GREAT WOLF LODGE, CHESTERTON, BICESTER

Proposed Non-Material Amendment (S.96a) Application Design Changes

November 2023

SW1 South West Elevation 1
1:500

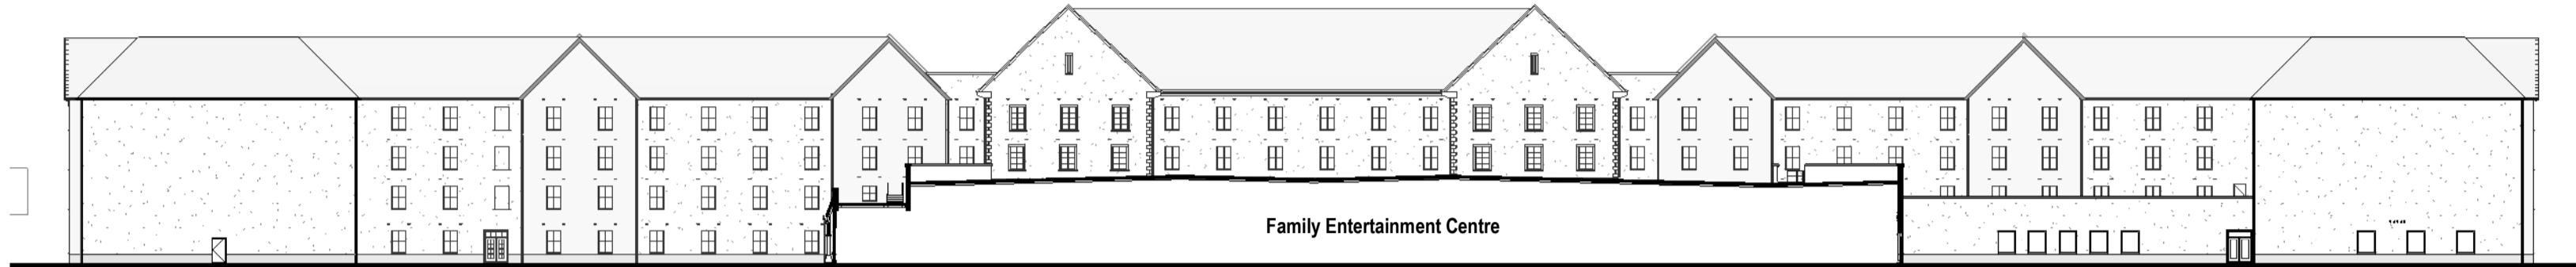
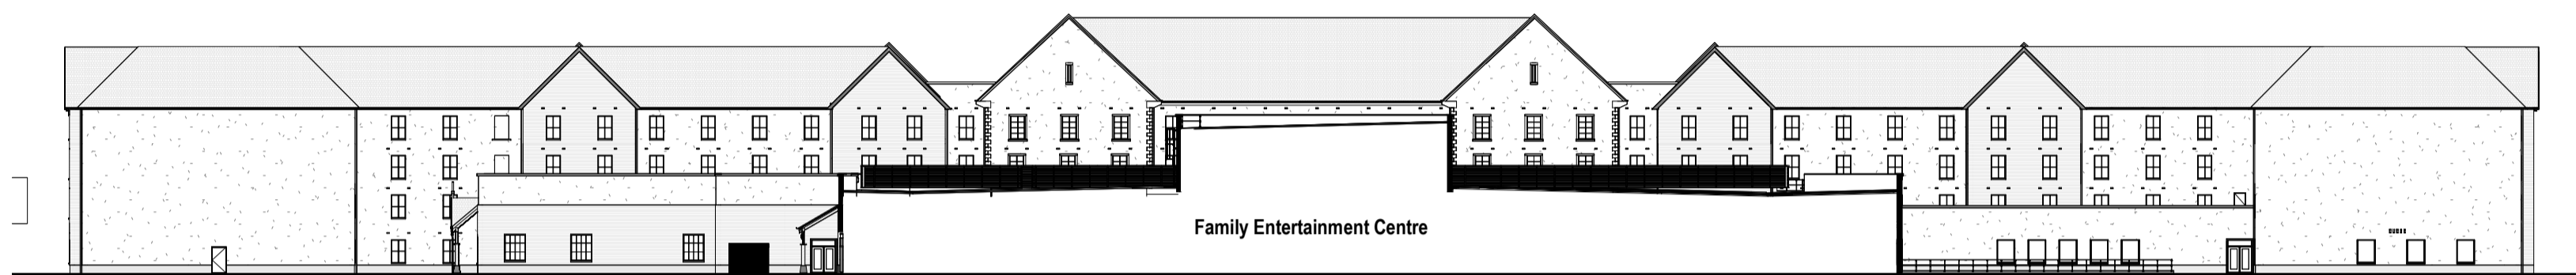
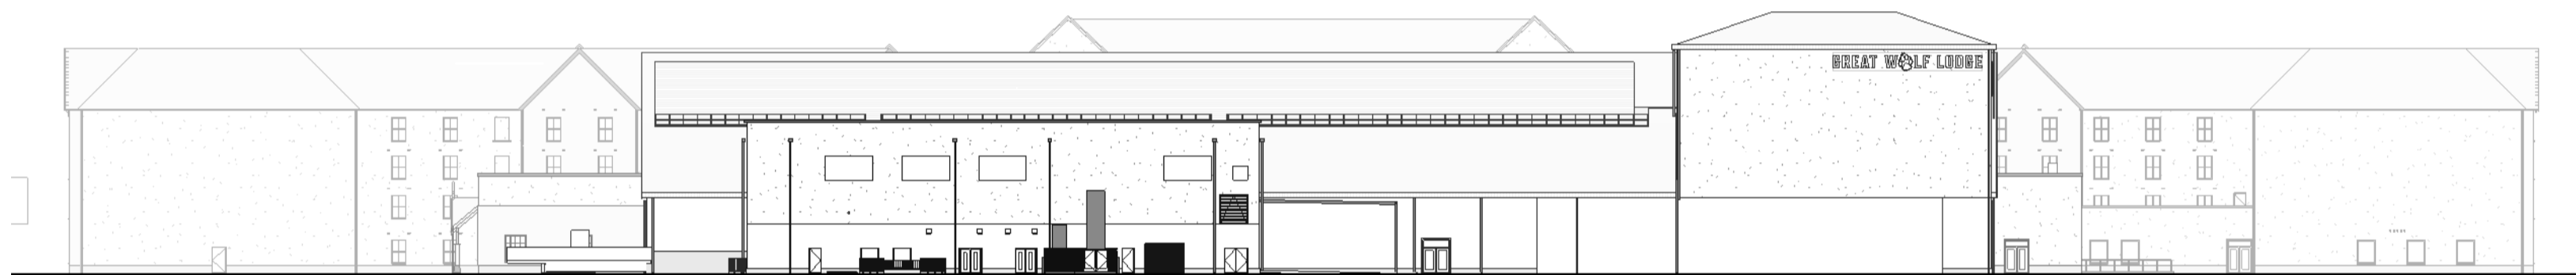
- ① Change of rear of hotel from stone to render retaining stone surrounds and sills
- ② Reduction of brick plinth to back of house areas of waterpark building / change to buff brick from blue brick material
- ③ Change of rear of hotel from stone to timber with timber surrounds and metal sills
- ④ Introduction of Ventilation grilles above all guestroom windows

NW1 North West Elevation 1
1:500

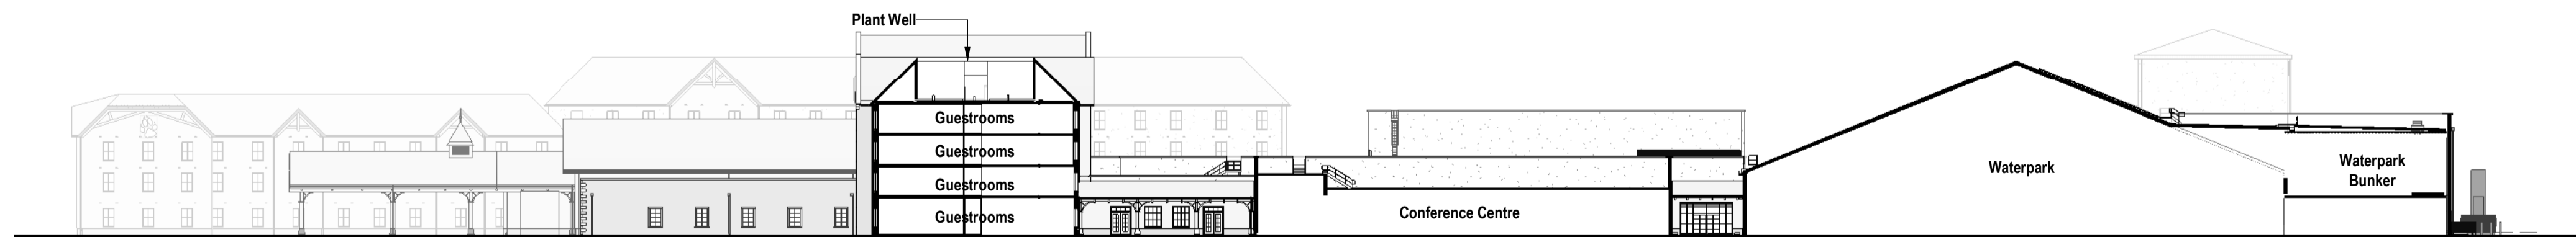
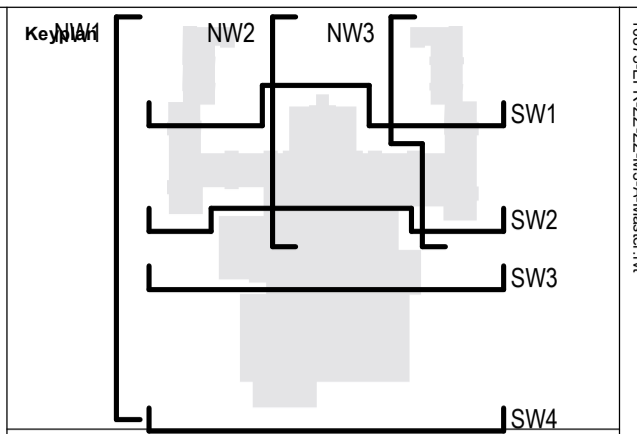
- ① Introduction of ventilation grilles above all guestroom windows
- ② Reduction of brick plinth to back of house areas of waterpark building
- ③ Reduction of plant screening above conference zone

- ① Introduction of ventilation grilles above all guestroom windows
- ② Reduction of extent of plant screening above conference zone where plant is no longer present.
- ③ 250mm width increase of roof access platform for safer access.
